**Exhibition of Modification Request for The Star City Casino (MP 08_0098 MOD 13)
20-80 Pyrmont Street, Sydney**

Thank you for your letter dated 20 August 2018, requesting Transport for NSW (TfNSW) review and comment on the above.

04 DETAIL Signage Location - Porte Cochere
1:50

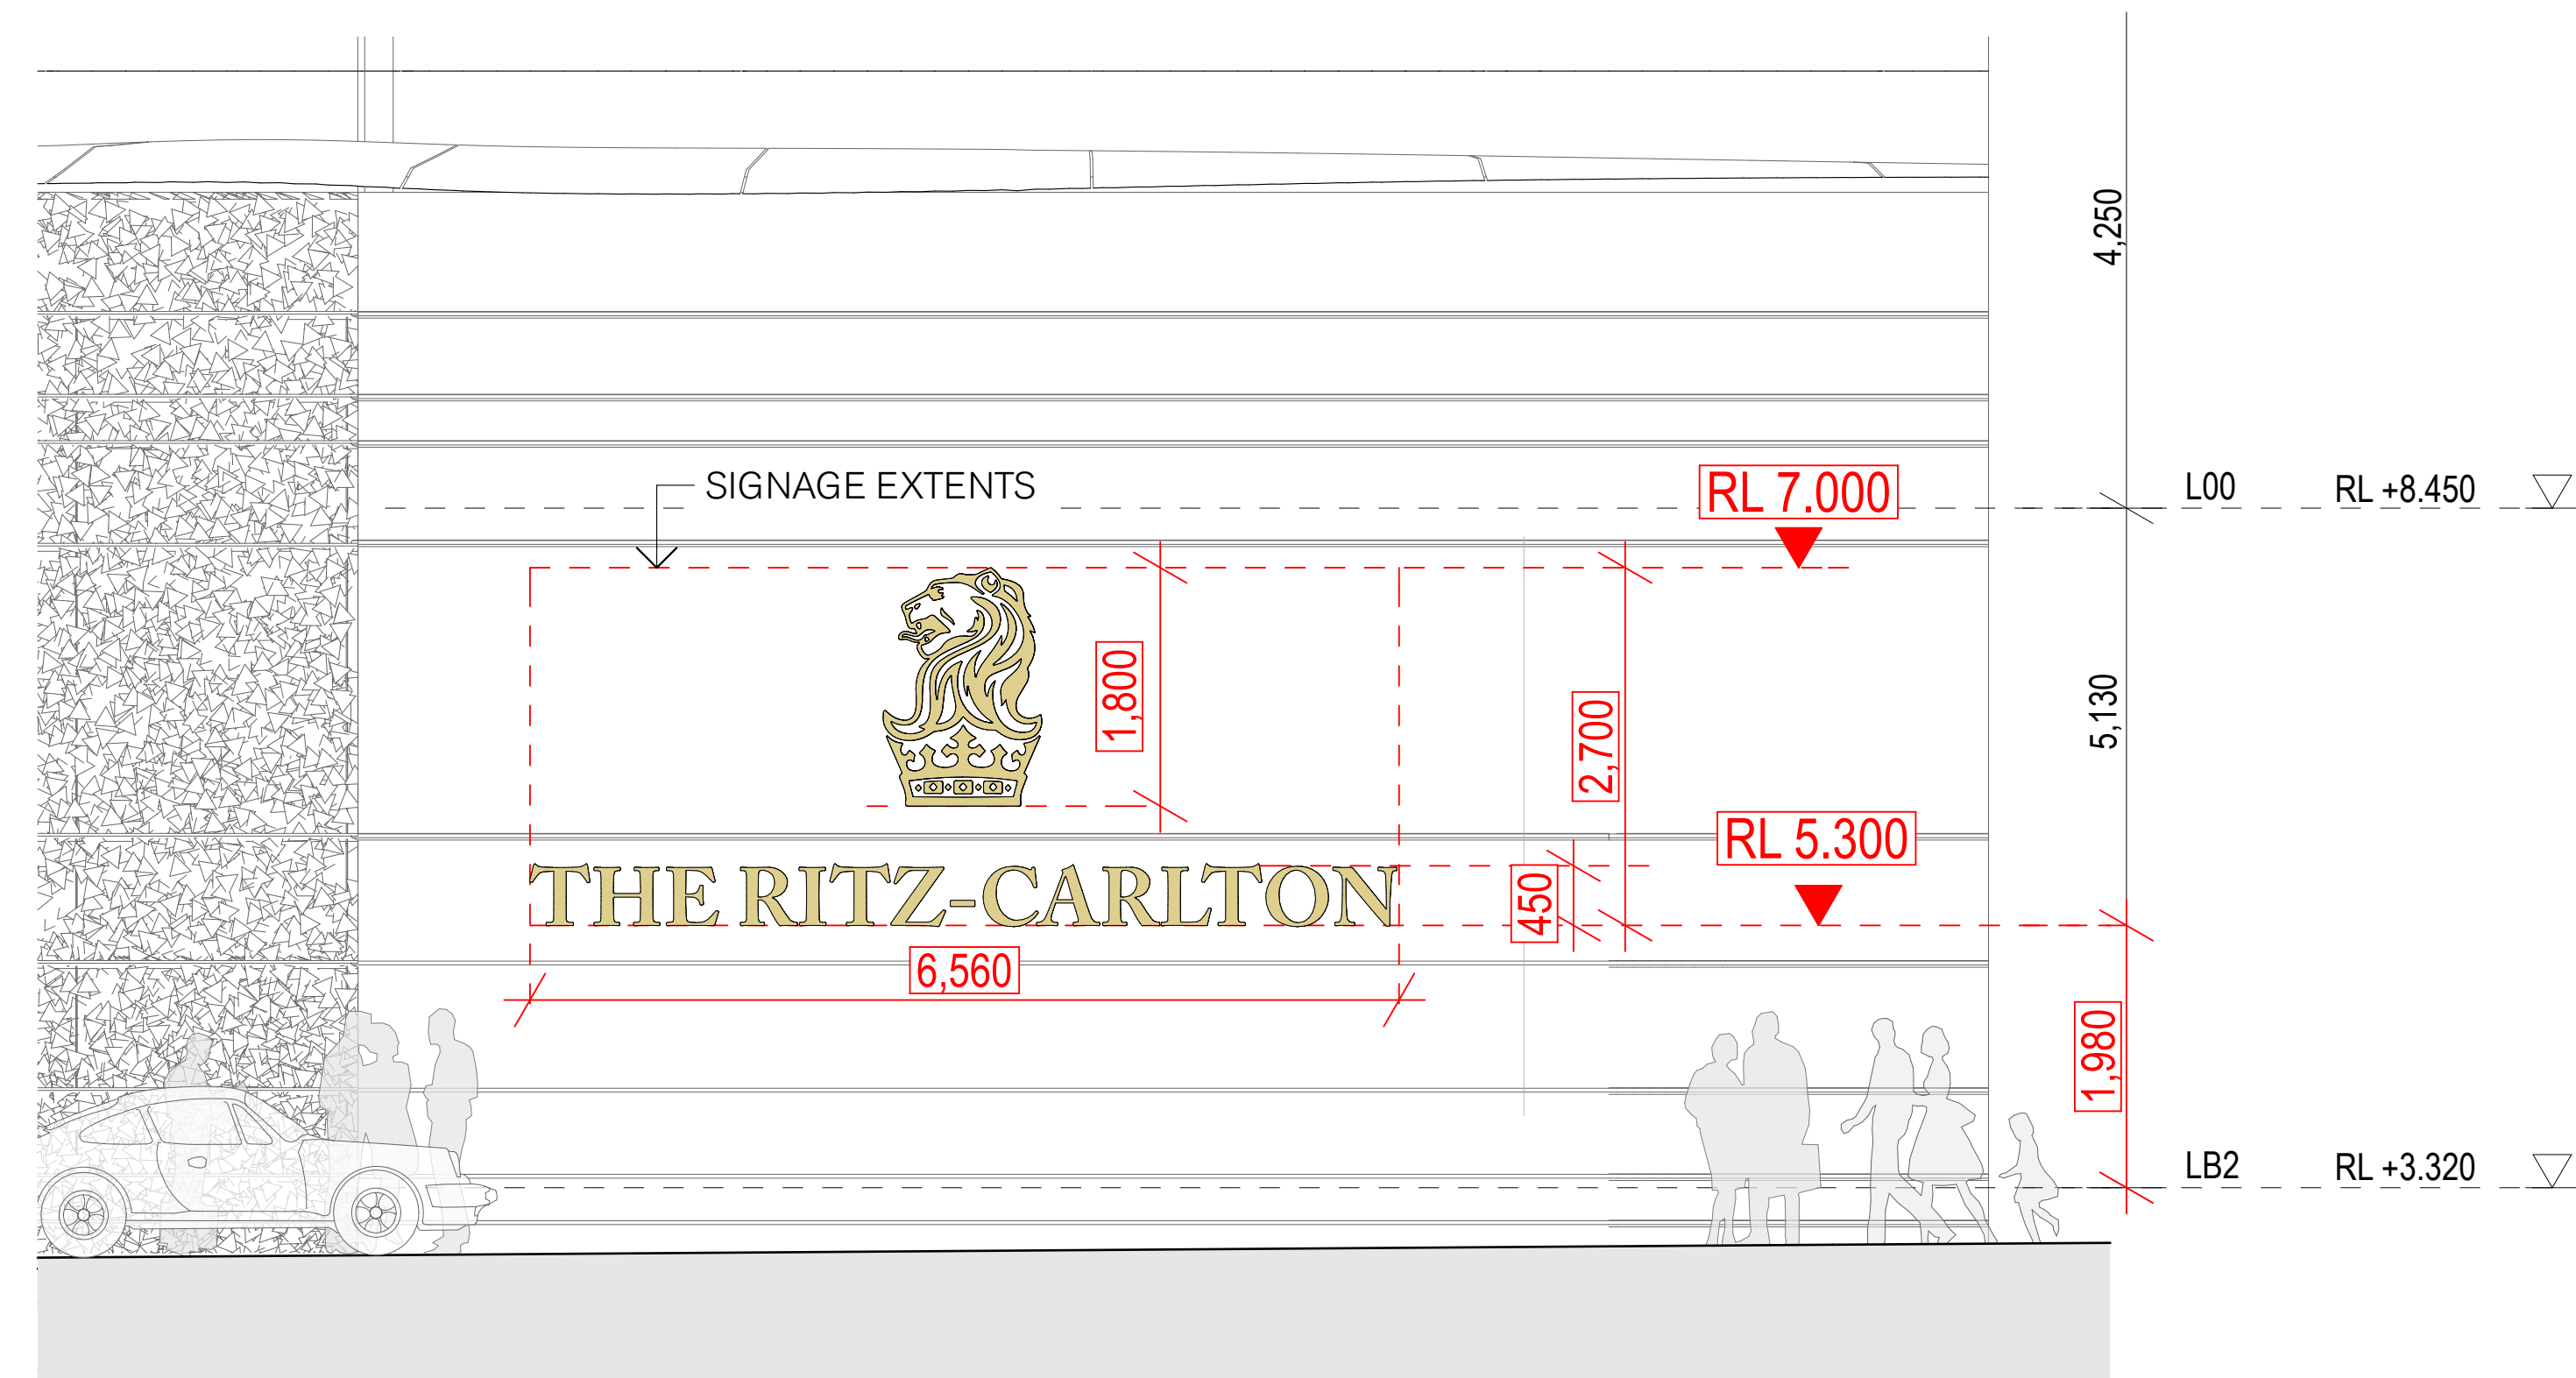
Changes to the existing bus stop on the western side of Pirrama Road are proposed to accommodate the proposed porte cochere.

The Traffic Impact Assessment (Traffic Report) prepared to support the proposed development states that the new Port Cochere has set-down and pick-up areas for up to 6 taxis or 2 to 3 coaches. Details on how the forecast demand for the Porte Cochere by time of day or by users has not been provided. In addition the Porte Cochere is situated in close proximity to the Pirrama Road bus stop and may impact on the bus stop operation.

It is requested that the applicant consult with Sydney Coordination Office regarding the detailed design of the bus stop to ensure bus operations and customers accessing the bus stop are not adversely impacted by the proposed modification.

It is requested that the applicant be conditioned to prepare a Porte Cochere Management and Operation Plan in consultation with the Sydney Coordination Office within TfNSW.
